Rustington - Latest Correspondence

Subject: RE: Former Hares site, Rustington [Filed 12 Dec 2018 17:43]

From: Laura Gibbons [REDACTED]
Sent: 04 December 2018 14:33
To: Chris Hendry [REDACTED] Ziyad Thomas [REDACTED]
Cc: Paul Cann [REDACTED]
Subject: Former Hares site, Rustington

| Project No: RRL012 | Drawing No: 505 | Revision: P8    |              |                |

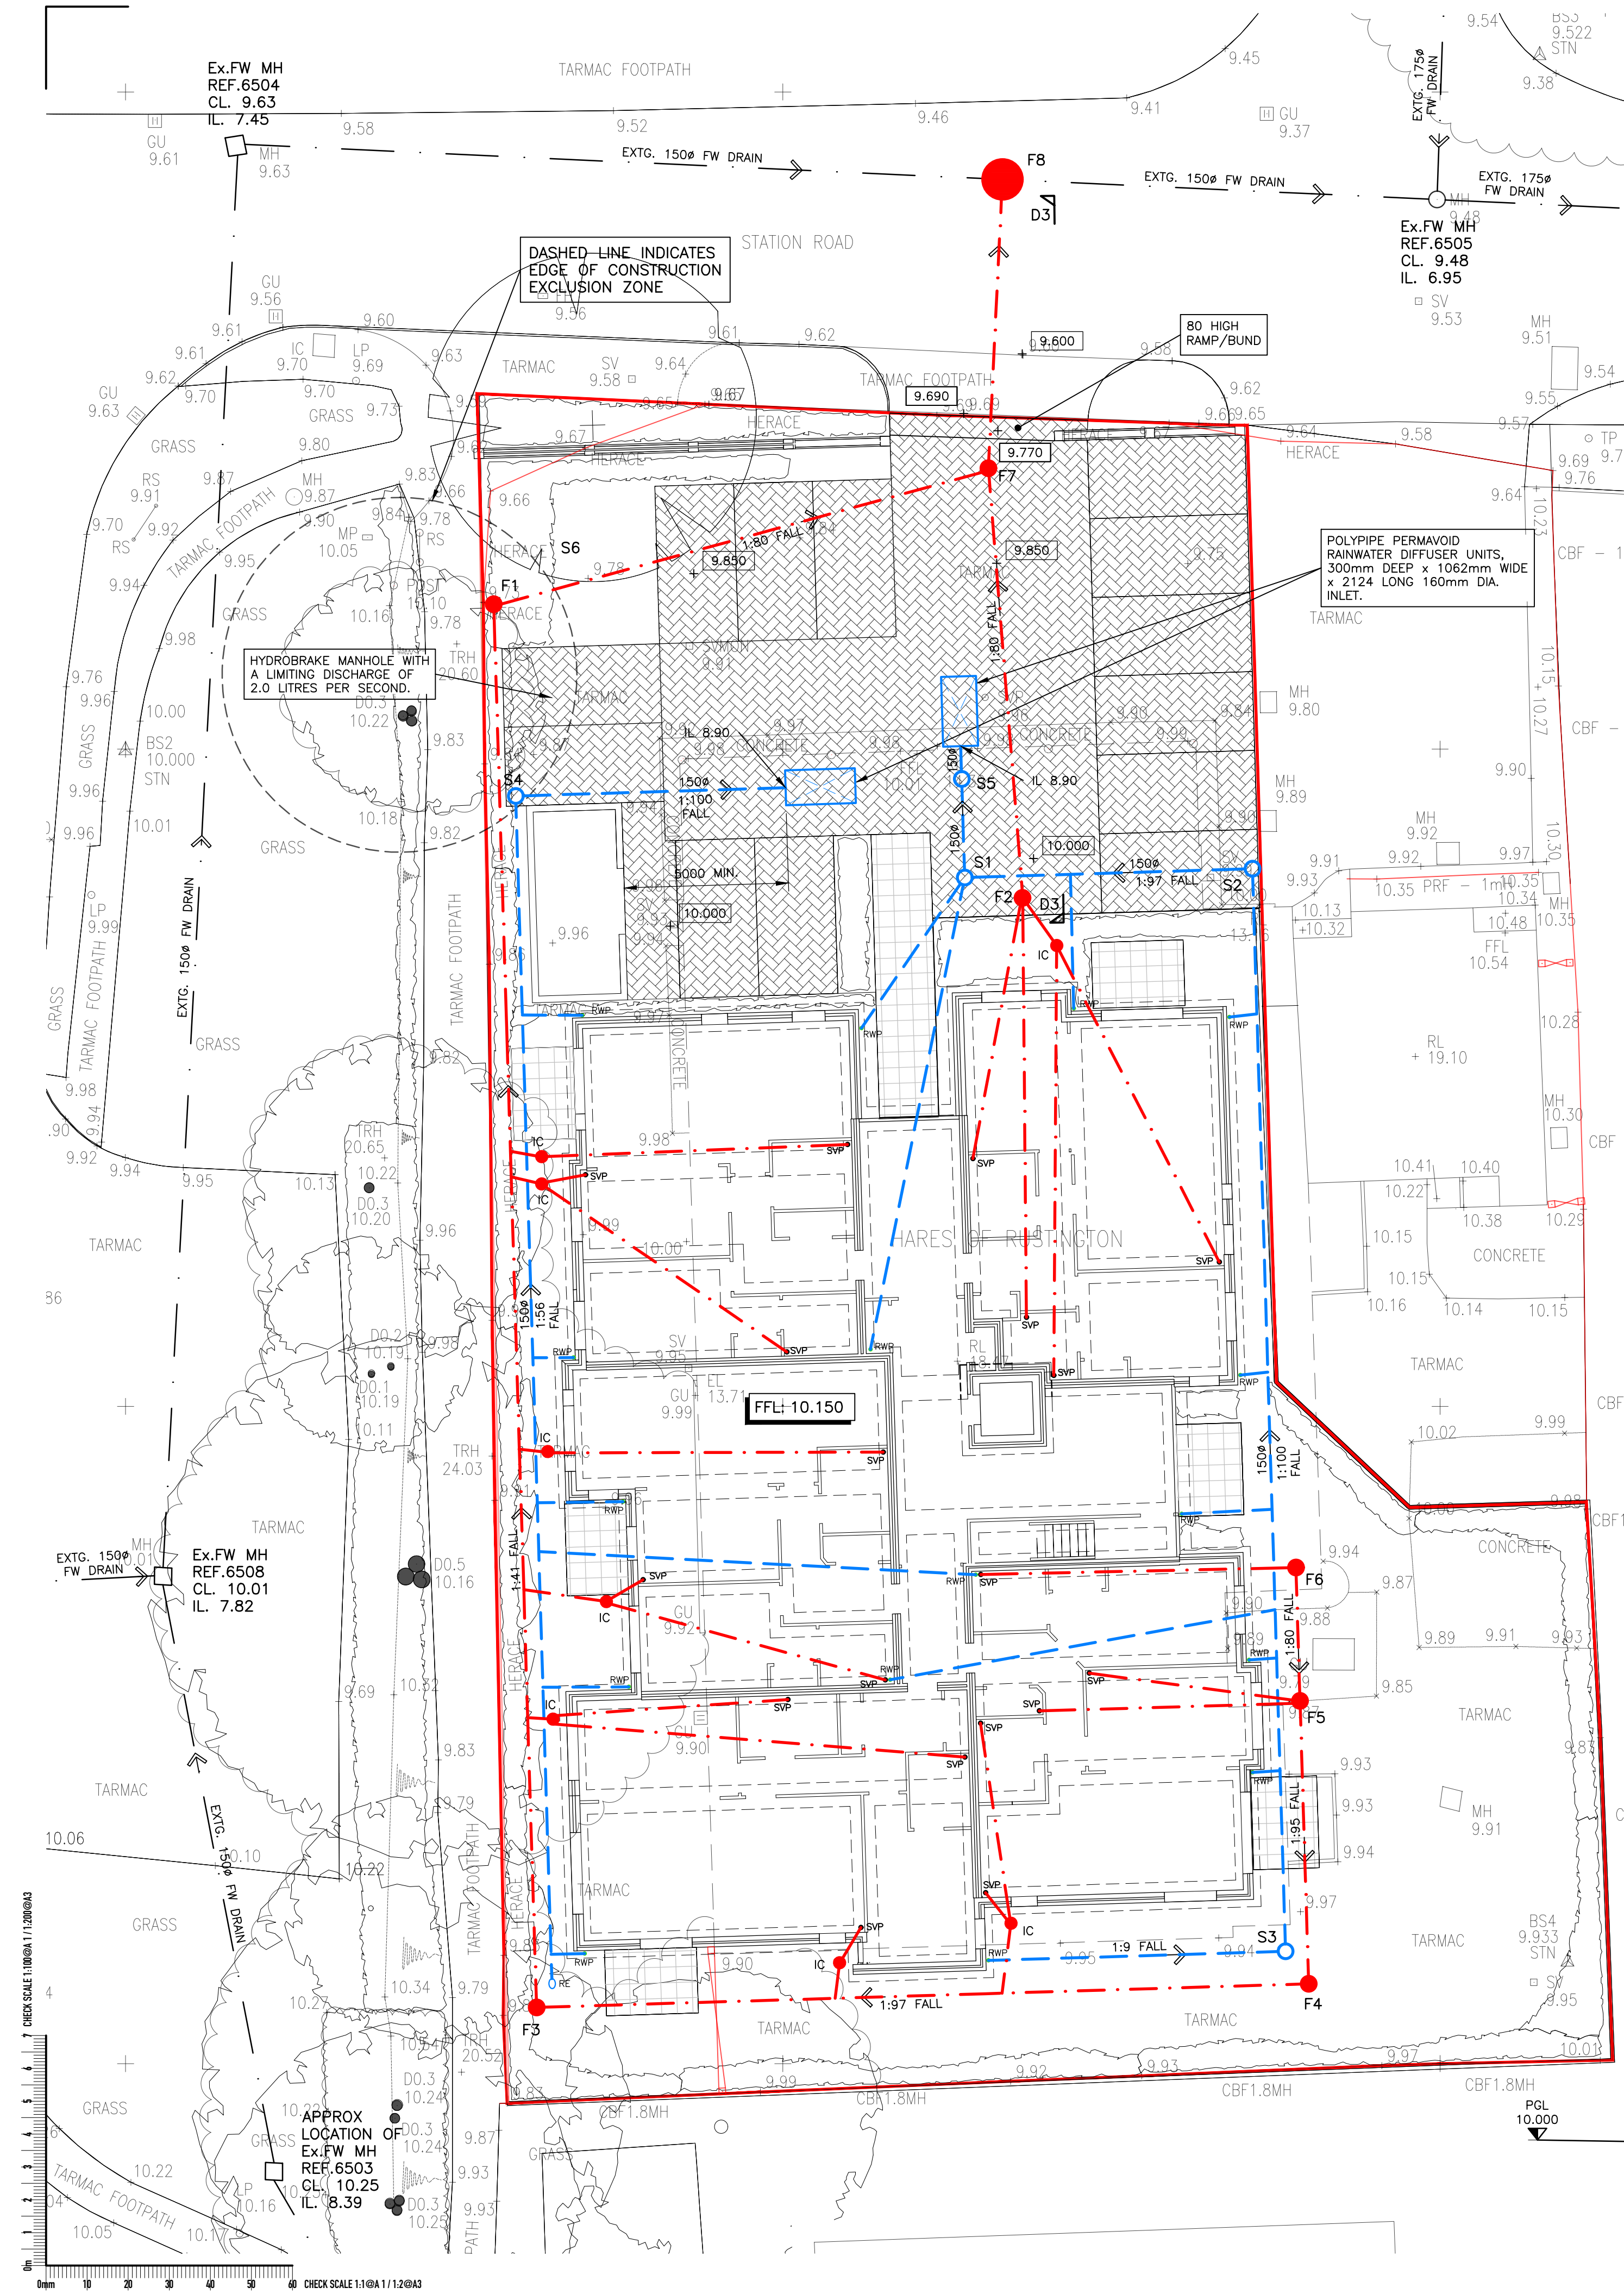
I have lowered F2 so that the foul runs beneath the subbase and have used oversized diffuser units and catchpit manholes to mitigate the risk of blockage over time.

1. The infiltration rate used in calculations is to be checked and calculations revised if required. 2.4×10^{-6} appears to be used in calculations, whereas 2.4×10^{-5} was found on site.

2. The permeable paving is to be used to take roof water and water from the paving itself.
3. If required a gully could be installed (proper road gully construction) to act as a fail-safe should an extreme event occur. This gully would be located near the "sleeping policeman" in the access way. A 2/s control manhole will be located downstream of this, before connection into the southern water sewer.

4. If point 3 is taken forwards the optimising of the position of C2 will be examined to improve the angle of connection from the gully, so that its direction is not against the flow of water.

7. Should pipe levels be inappropriate to connect immediately into the subbase of the permeable paving a connected ring soakaway could be utilised.
8. Catch pits will be provided upstream of all connections into the permeable paving.

9. Points of diffusion into the permeable paving should be located 5m from buildings.
10. F2 will be lowered so that the foul water pipe is below the permeable paving construction.

We have managed to prove the subbase using infiltration alone based on the revised infiltration figure and have provided a minimum 1m deep build-up for conservatism and due to the falls required in the pipes leading from the back of the building to the front.

As discussed in our meeting, we accept that should the subbase back-up then the exceedance flows would run off site to the North, which means risk to the building is minimal. We also note that the bund would act to highlight issues within the permeable paving.

Scale	Paper Size	Date	Drawn By	Checked By
AS SHOWN	A1	JUNE 2017	JH	CH
Project No.	Drawing No.	Revision		
RRL012	551	P3

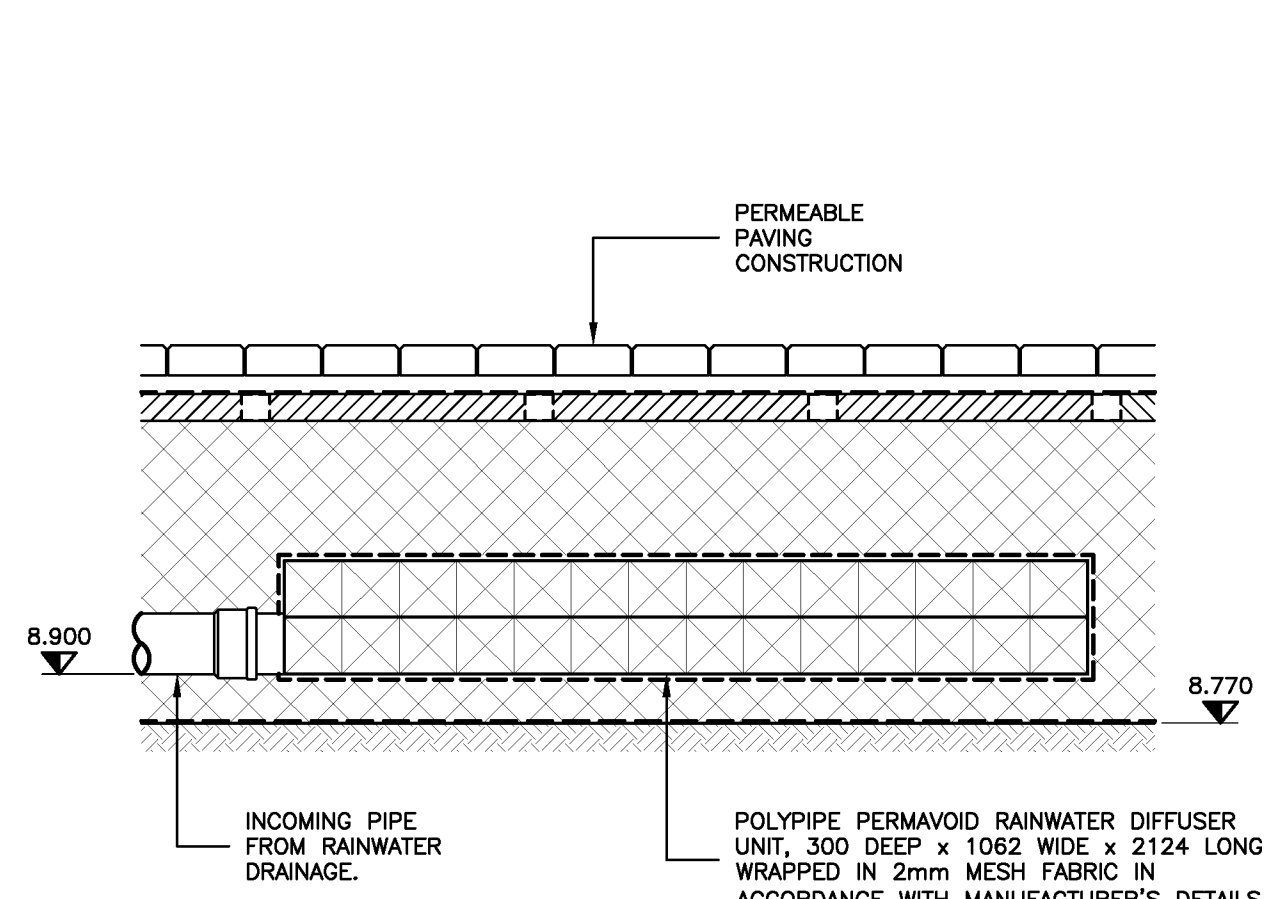
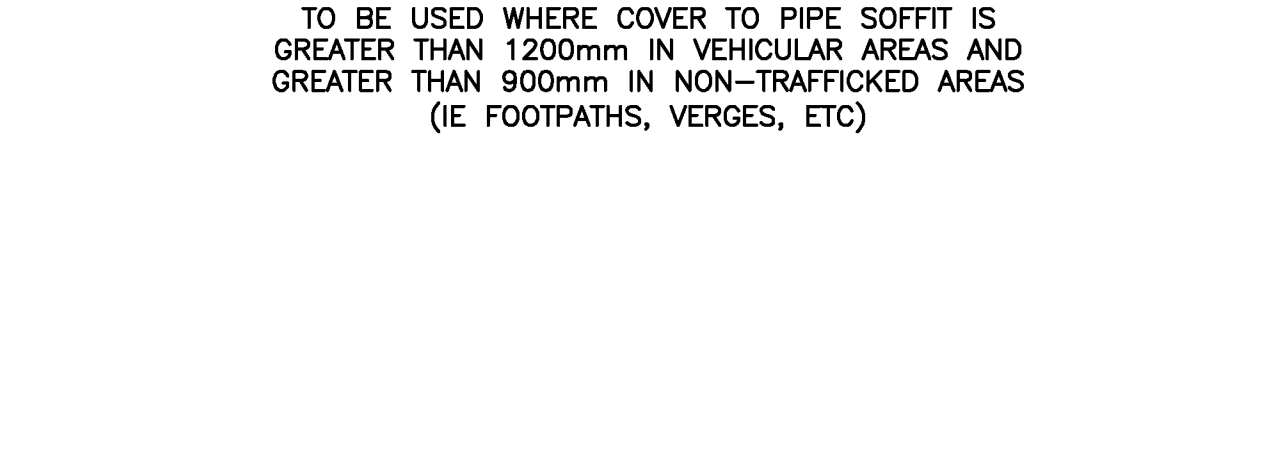
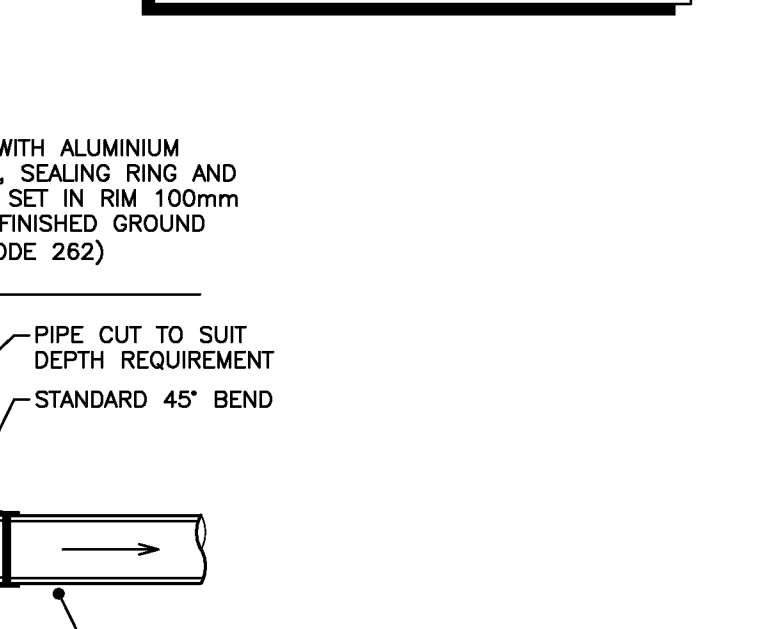
I have a ground level of 9.90 to 10.00 m on site. You have plenty of spare room in the sub base (i.e. nowhere near capacity), I think reducing it a little would be of benefit unless you can provide confirmation of the infiltration test depth relative to OD.

Can you please ensure the base of the permeable paving is at the depth of the nearest infiltration test which was 1m deep. If achieving sufficient falls on the pipes from the back of the property is problematic please use ring soakaways.

The proposed levels are slightly above existing as you work back from the front of the site and the soakage test at 1m deep was completed in an area with a ground level of 9.60, so I had hoped our formation level of 8.770 would be suitable.

We have set the base at 8.77mAOD, which is 1m down from the ground level at the front of the site where the infiltration test was taken. Is this acceptable?
